Rezoning Transportation Analysis

Petition Number: 2022-156

Date	Description
02-23-23	First Review (JLP)

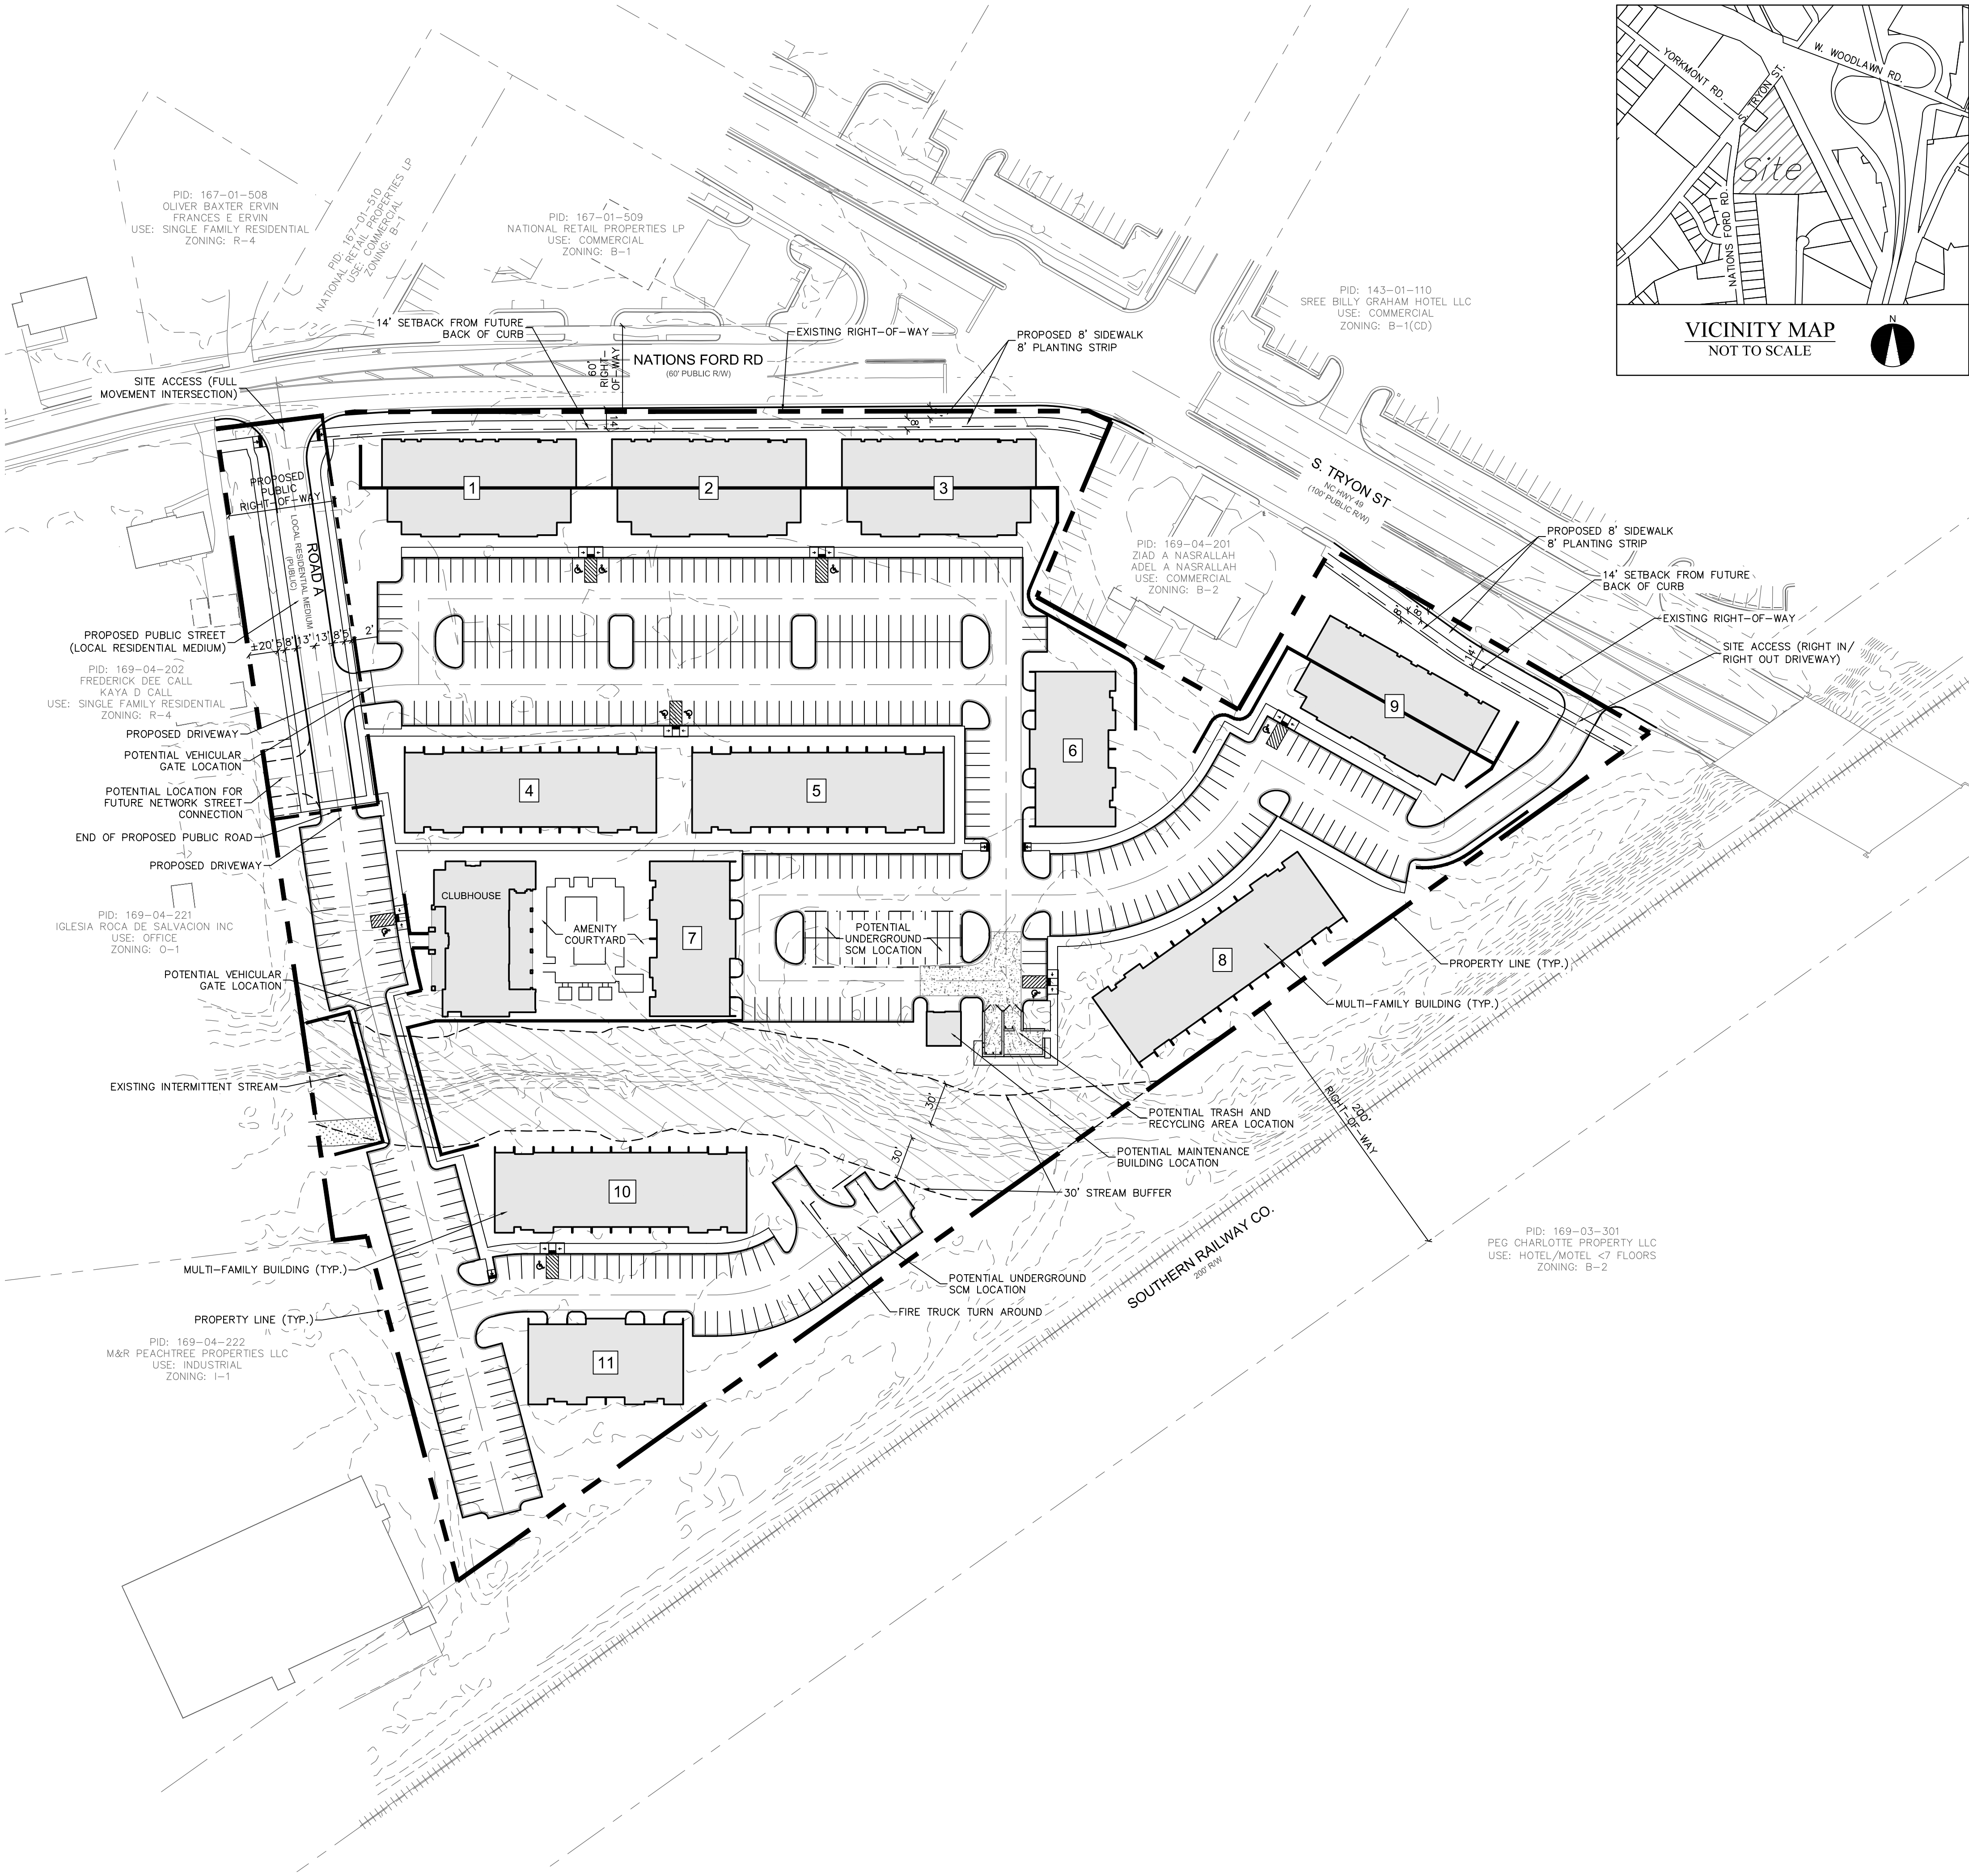
- South Tryon Street:** Location of the future curb and gutter to be installed at 41 feet from roadway centerline to accommodate the Charlotte Streets Map roadway typical section of a six plus lane avenue with shared use path. The future curb and gutter should be shown on the plan and dimensioned from the centerline.
- Nations Ford Road:** Location of the future curb and gutter to be installed at 27 feet from roadway centerline to accommodate the Charlotte Streets Map roadway typical section of a two plus lane avenue with buffered bike lane. The future curb and gutter should be shown on the plan and dimensioned from the centerline.

Label and dimension the curb and gutter from the centerline of each road on the site plan.

- Revise site plan to dimension the right-of-way and back of curb on South Tryon Street, Nations Ford Road, and Road A.
- Revise site plan and conditional note(s) to commit to construct bicycle facilities on South Tryon Street by installing a 12' multi-use path to meet the Council-adopted Charlotte BIKES Policy. Multi-use paths maintained by the City shall meet ADA/PROWAG requirements.
- Revise site plan and conditional note(s) to commit to construct buffered bike lane bicycle facilities on Nations Ford Road by locating the curb and gutter 27' from the center line to meet the Council-adopted Charlotte BIKES Policy. Multi-use paths maintained by the City shall meet ADA/PROWAG requirements. Provide bike ramp along Nations Ford Road near South Tryon Street to transition from the buffered bike lanes to the multi-use path on South Tryon Street.

6. Revise site plan and conditional note(s) to commit to dedicate 35' right-of-way from the road centerline on Nations Ford Road and 50' right-of-way from the road centerline on South Tryon Street. The site plan shall label and dimension the right-of-way from the road centerline.
7. Revise site plan and conditional note(s) to provide a stub for future connection. The stub shall be designed as a turnaround for vehicles prior to entering the private street.

8. Revise site plan and conditional note(s) to relocate the proposed gate a minimum of 40ft from the right of way on Road A

9. Revise site plan and conditional notes to commit to providing a right turn lane at the proposed site access on South Tryon Street. "Potential" should be removed from the callout. Per coordination with NCDOT this right turn lane will be required.

11. Revise site plan and conditional note(s) to commit to removing all existing driveways along the project frontage that will not be utilized by the project and restore the curb line with standard 2ft6in curb and gutter.

12. Revise site plan and conditional note(s) to commit to restriping Nations Ford Road to remove the existing left turn lane that will not be utilized with the project and provide a full width left turn lane at the proposed site access. Additional widening should be provided to incorporate the left turn lane.
